**From:** alan.story@hertfordshire.gov.uk  
**Sent:** 04 June 2018 11:00  
**To:** Planning  
**Subject:** Planning application 6/2018/1338/FULL - Premier Inn, Stanborough Road

**District ref:** 6/2018/1338/FULL  
**HCC ref:** WH/158/2018  
**HCC received:** 01/06/2018  
**Area manager:** Manjinder Sehmi  
**Case officer:** Alan Story

Premier Inn, Stanborough Road  
Welwyn Garden City  
AL8 6DQ

Erection of a three-storey extension to the northern elevation of the existing hotel and a single storey extension to existing entrance lobby (C1), alterations to car parking layout, landscaping and associated works.

Proposed Site Plan

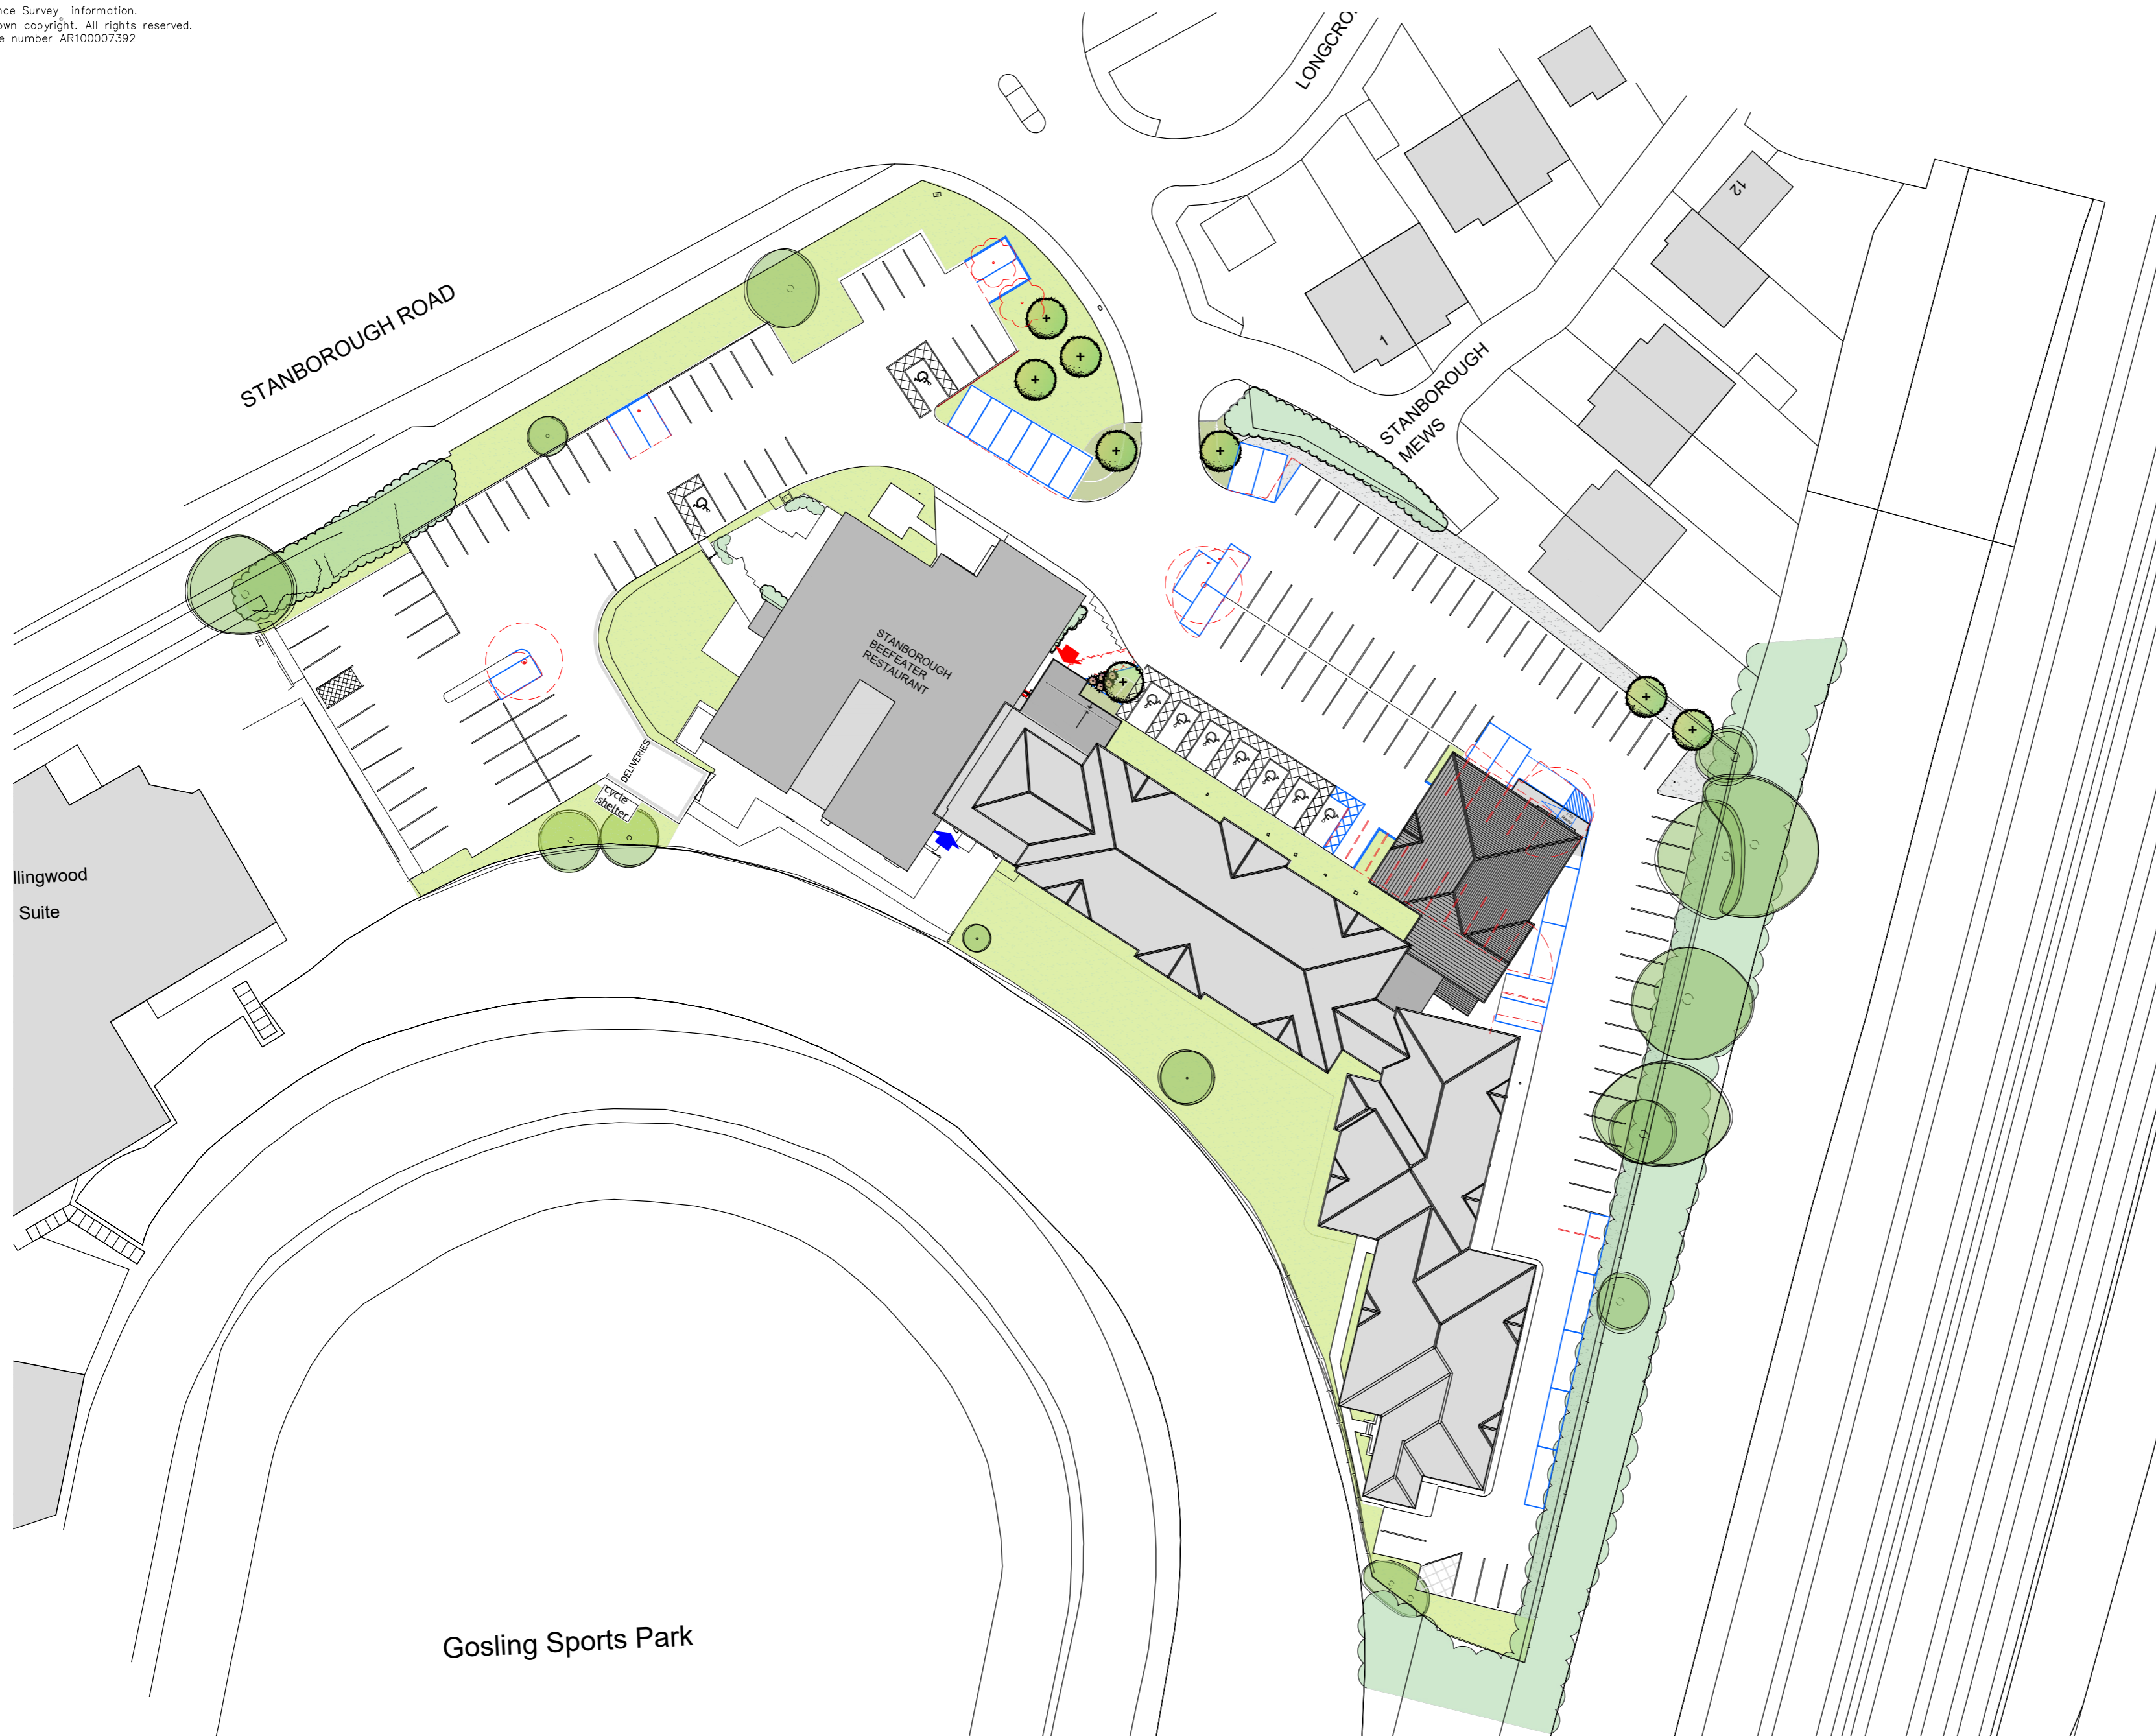
Parking lost as a result of the siting of the new hotel wing, is reprovided across the site (including the additional parking). All bays provided appear suitable. Some bays are provided parallel to the rear access road (Eastern boundary of the site), and may restrict ease of two way flow of vehicles but this area provides limited parking and therefore unlikely to result in significant difficulty. Additional bays are provided within existing landscaping. Or amendments to existing layout.

I would observe that one single space appears to be poorly laid out (adjacent to eastern corner of new block). I would therefore highlight that actual net increase in spaces would be more reasonably be 10 not 11, as this space is unlikely to be used to limitations on its' scale and potential for interference with use of surrounding bays.

The hotel provides 8 cycle spaces for the 120 bedrooms, and this number is unchanged following the increase of 24 additional bedrooms. It is, however, accepted that primary users of these facilities would be staff who may be local to the site. The additional bedrooms are predicted to give rise to a further 4 staff.

The LPAs own cycle parking standards would suggest the provision of 1 long term space per 10 bedrooms, as well as 1 long term space per 10 staff on site at anyone time. On the basis of the LPAs own standards, there is a shortfall in parking, and reasonably would require 16 cycle spaces. The Highway Authority would encourage that additional cycle parking be provided, as this shall support alternatives to the use of the private car for guests / staff and would support the objectives of the Highway Authorities Local Transport Plan, as well as ensure compliance with the LPAs' own standards.

1) Prior to the first occupation of the development hereby permitted the proposed onsite car parking shall be laid out, demarcated, levelled, surfaced and drained in accordance with the approved plan and retained thereafter available for that specific use. Concurrent with this cycle parking shall be provided in accordance with a detailed scheme submitted to and approved in writing by the Local Planning Authority and retained thereafter available for that specific use. Reason: To ensure the permanent availability of the parking / cycle parking, in the interests of highway safety and to ensure sustainable development.
